Mr Joerg Arnhold, Rookery Farm, Pagham Road, Nyetimber, Bognor Regis

Reference P/76/16/PL
Location Sefter Farm Pagham Road Pagham PO21 3PX
Applicant Barfoots of Botley Limited

Re. Planning Application for Barfoot's of Botley, Sefter Farm P/76/16/PL

client			
BARFOOTS OF BOTLEY			
project			
Proposed Production Facility			
Setter Farm			
Pagham			
title			
Proposed Elevations			
date	scale @ A1	drawn	chkd
May 2016	1:200@A1	KJB	GBC
project no.	drawing no.	rev	
1603	P107	05

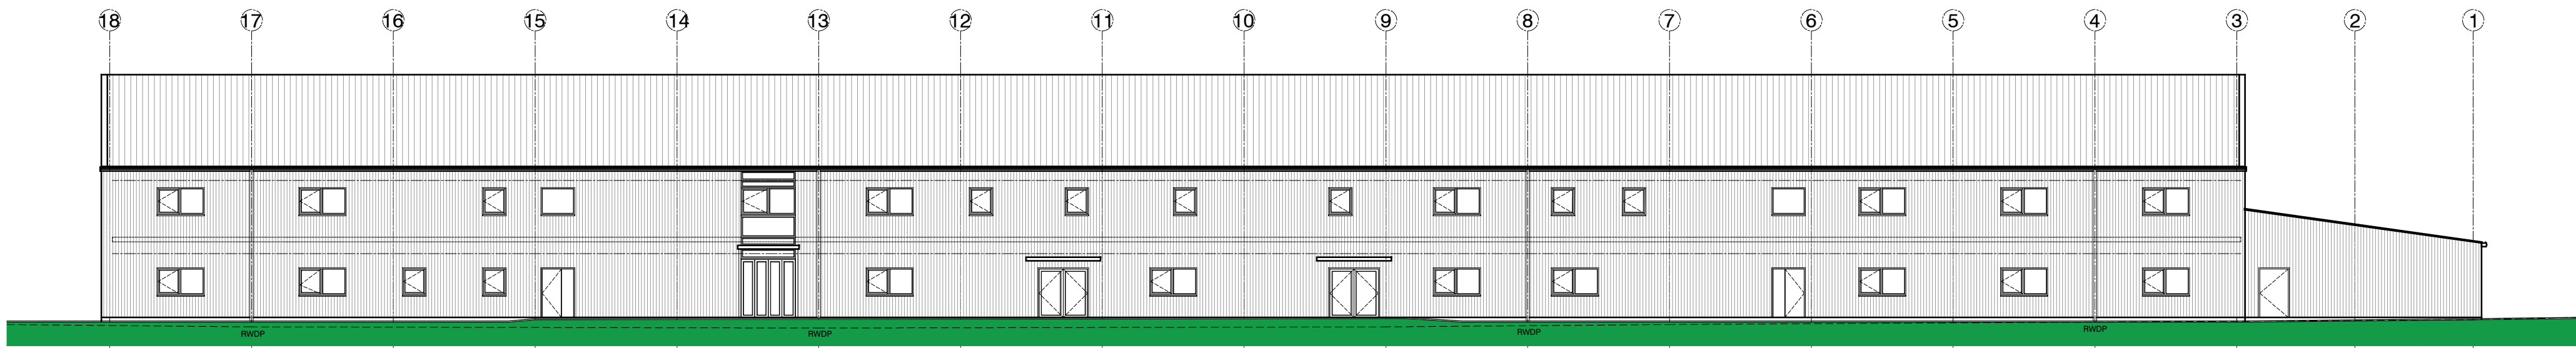
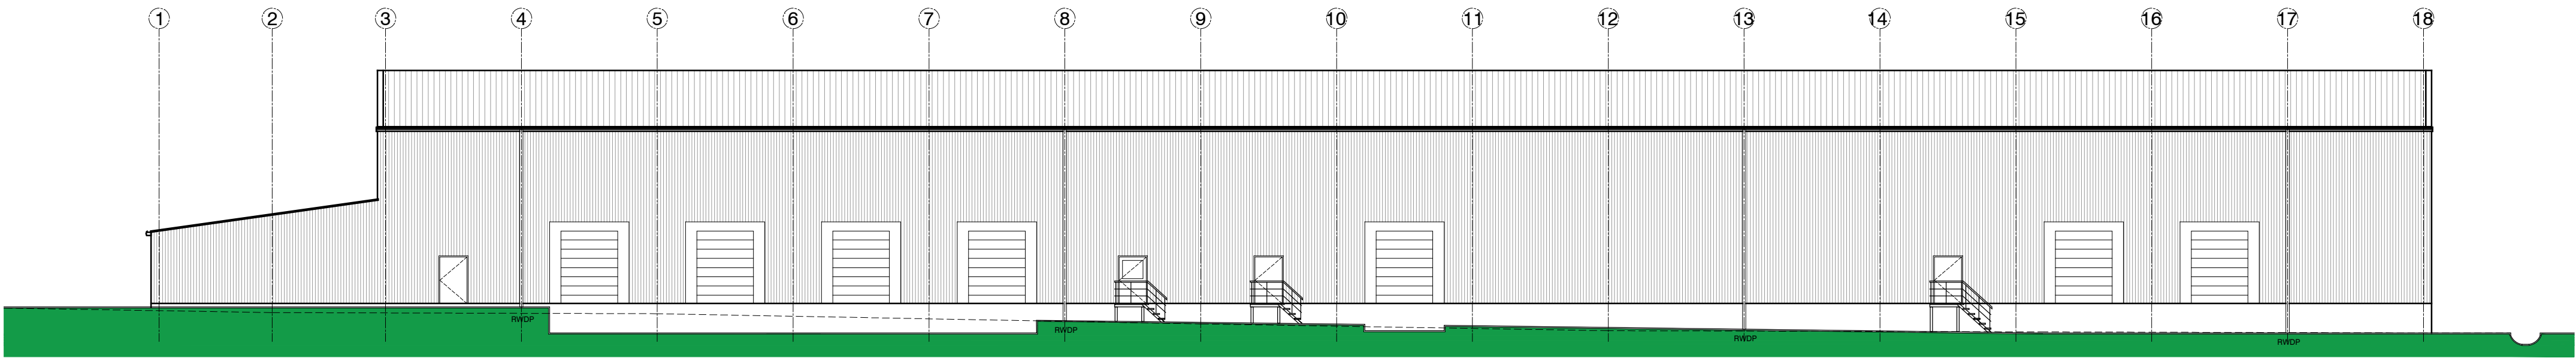
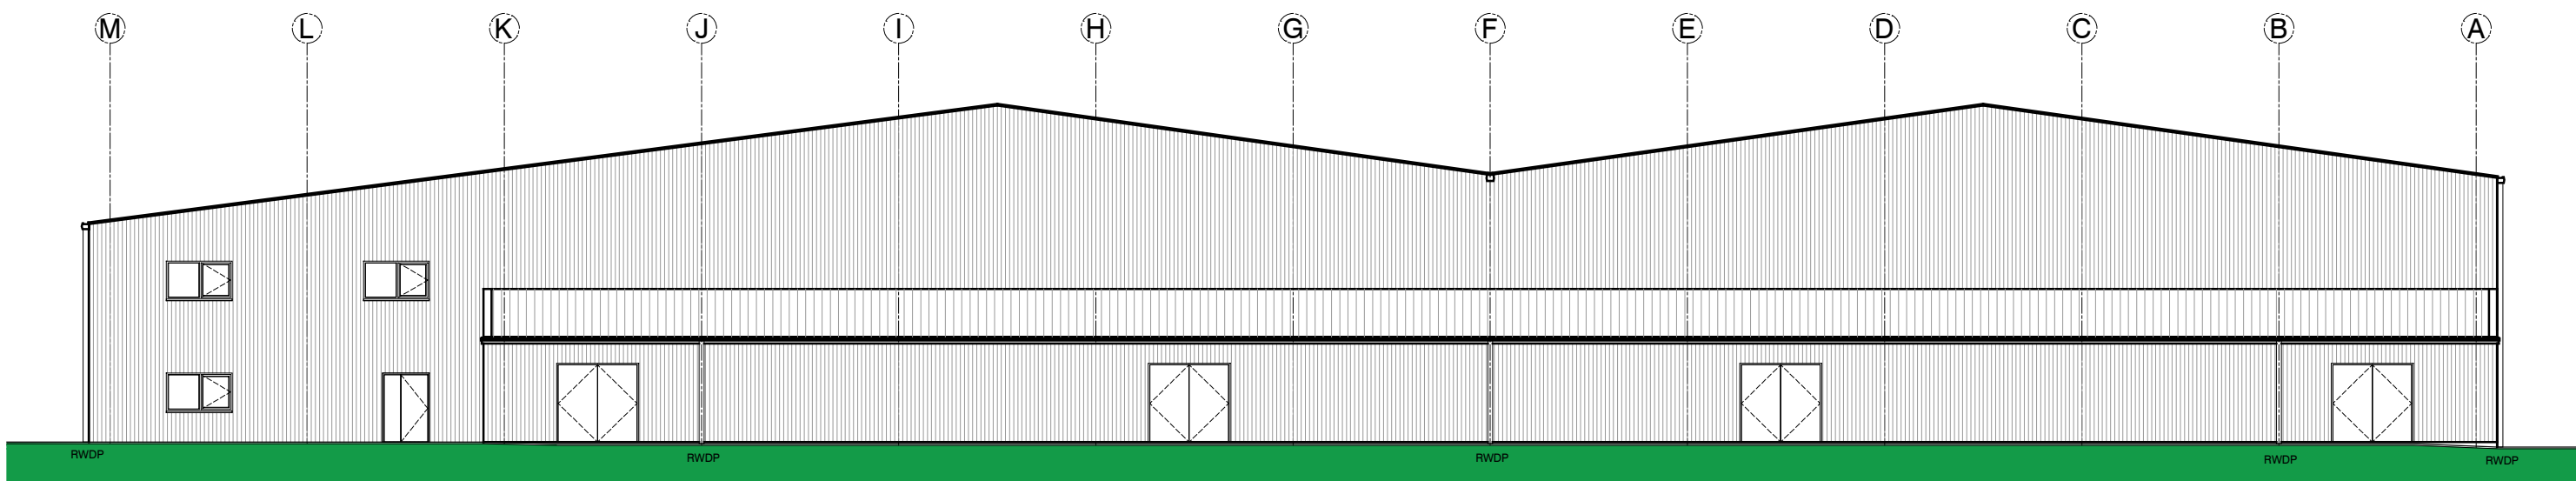
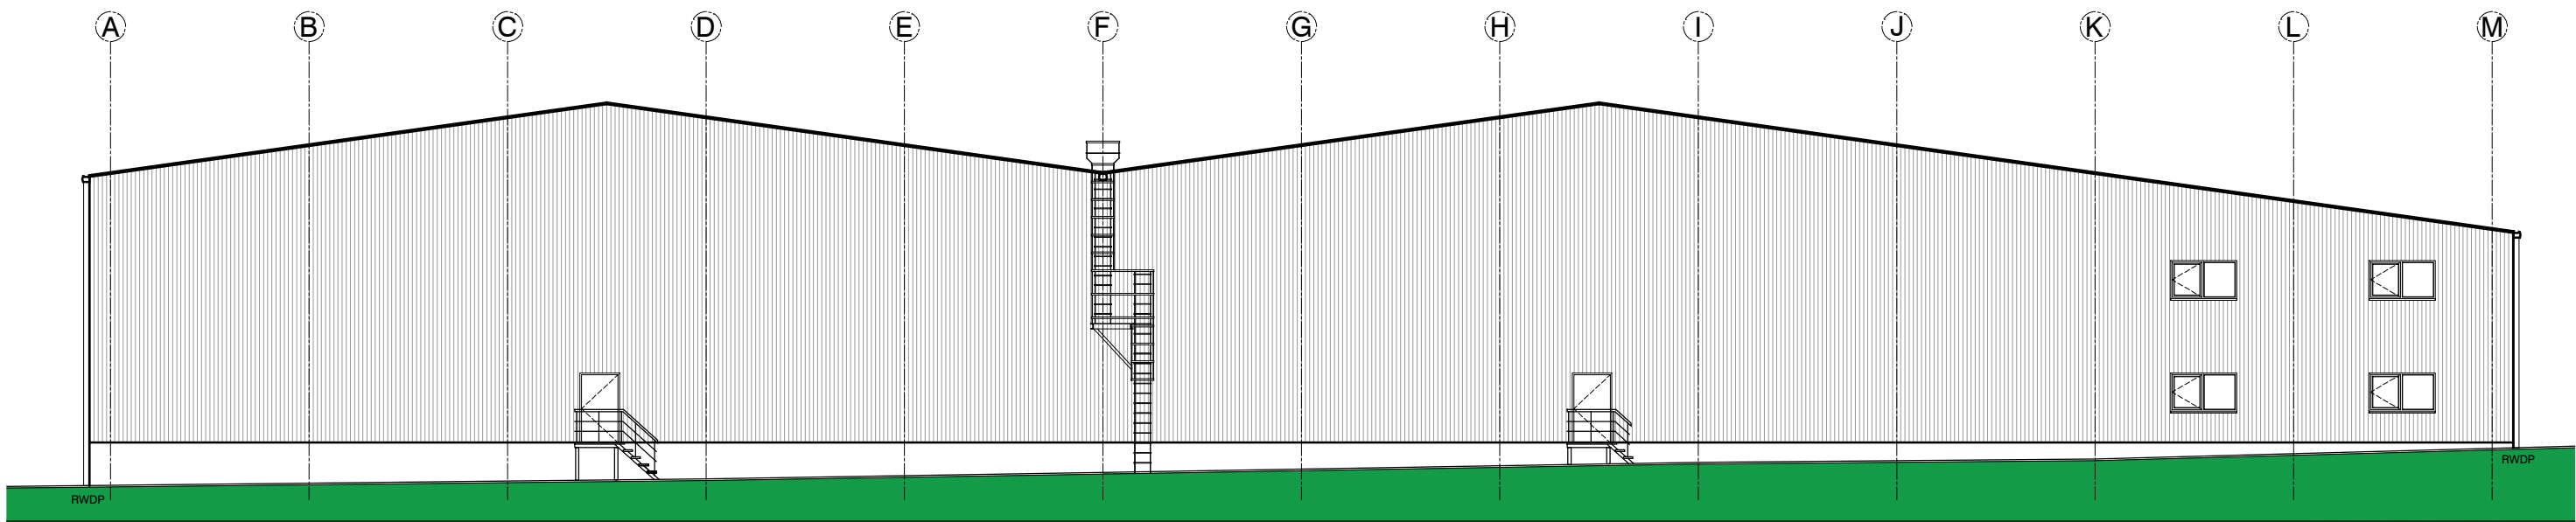
The packhouse plans show the south elevation raised by ca. 1.0 metre which in effect raises the roofline to 11.00 metres.
